Application for a non-material amendment following a grant of planning permission.

Number	
Suffix	
Property name	Cinders Lane Nursery And Works To The Rear
Address line 1	Cinders Lane
Address line 2	
Address line 3	
Town/city	Yapton
Postcode	BN18 0JJ
Description of site location must be completed if postcode is not known:	
Easting (x)	498160
Northing (y)	102625

Approval of reserved matters following outline consent Y/5/17/OUT for 51 No. dwellings. This application affects a Public Right of Way.

Y/4/19/RES

Scale : 1:100 @ A2 Date : DECEMBER 2018
Drawing No : 19.14.P407 A

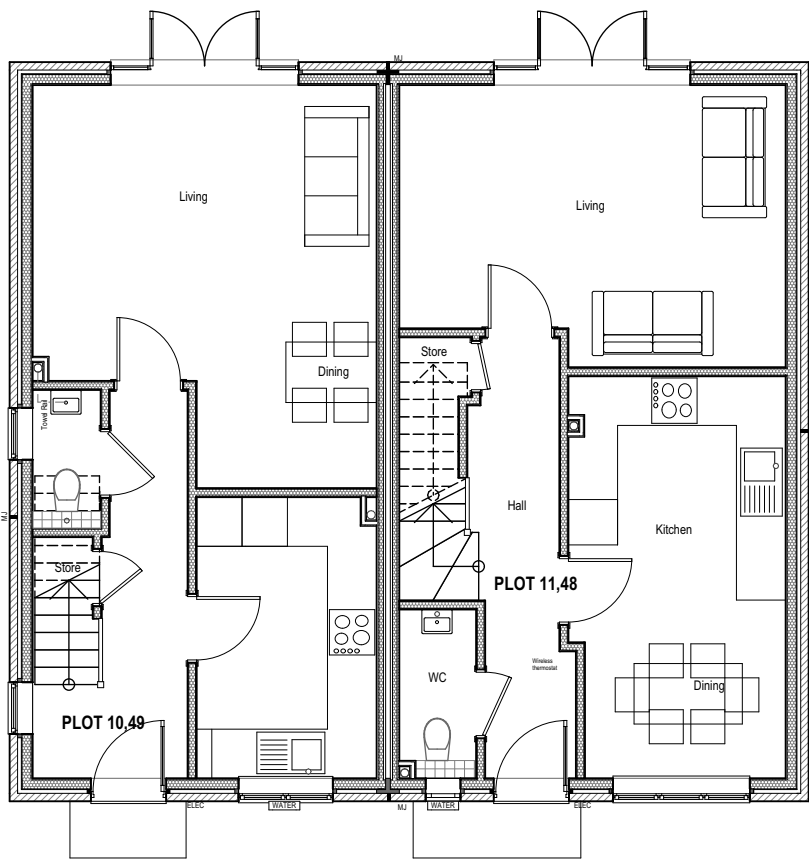
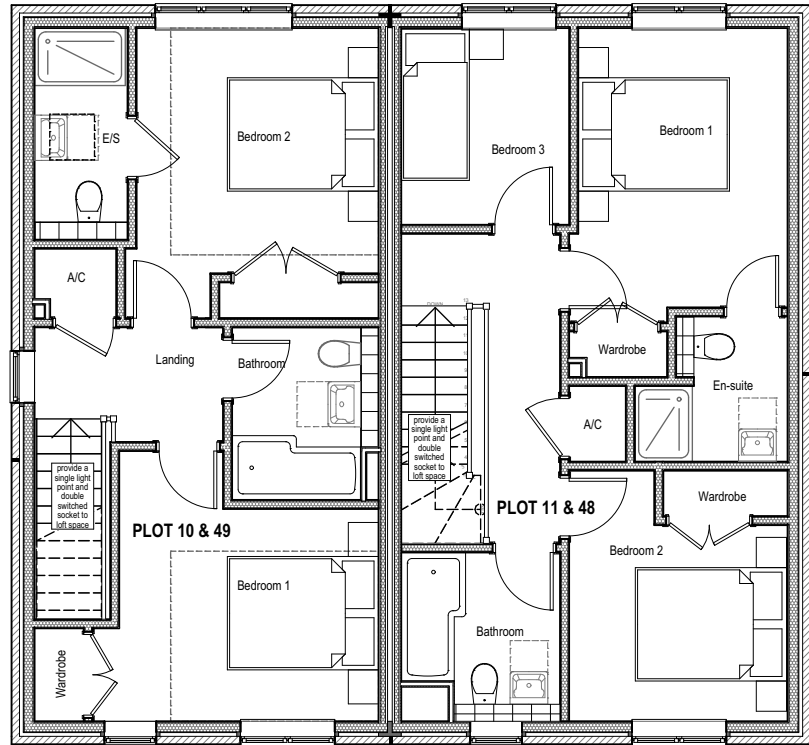
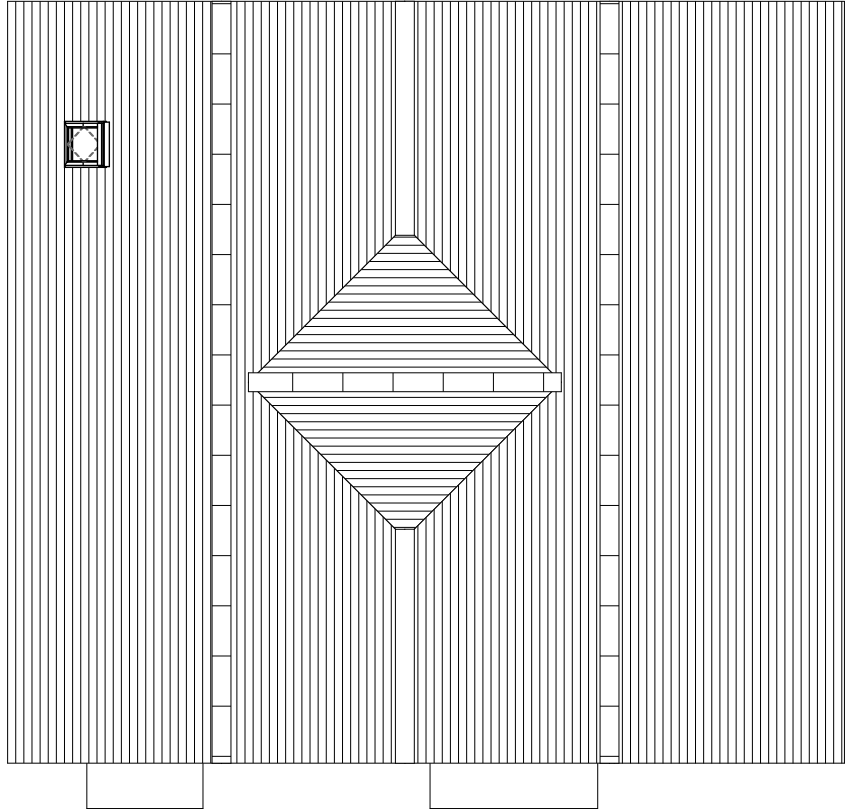
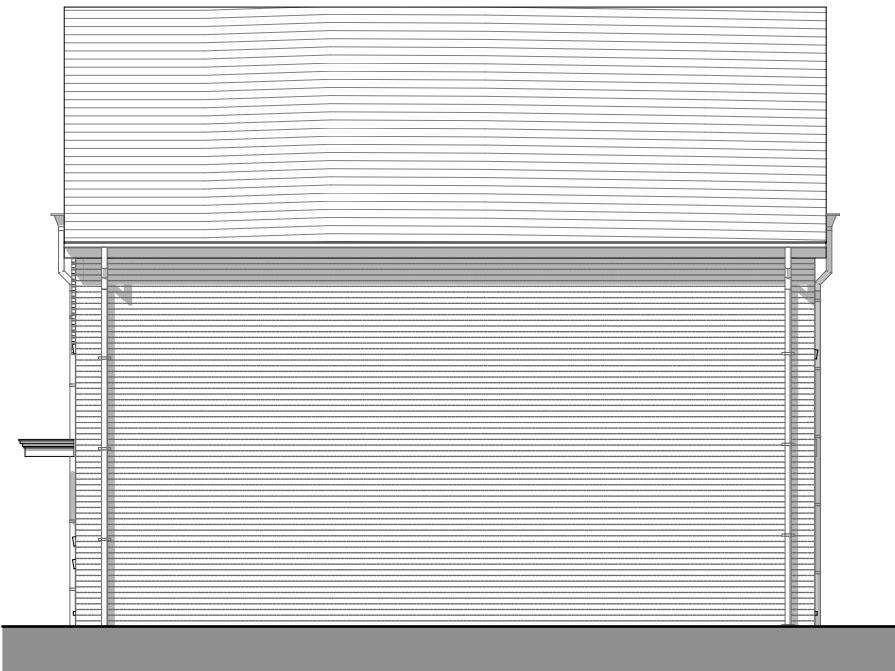
Addition of en-suite bathrooms to 6no. 2 bed houses (plots 10,28,29,49,50&51) including the addition of corresponding rooflights. Adjustment in horizontal position of rear facing bedroom windows to plots 10 & 49.

19.14.P407 Plots 10-11 & 48-49 Plans and Elevations
19.14.P414 Plots 28-29,37-38 & 50-51 (note plots 37-38 not subject to amendment)

19.14.P407_A Plots 10-11 & 48-49 Plans and Elevations
19.14.P414_1 Plots 28-29 & 50-51
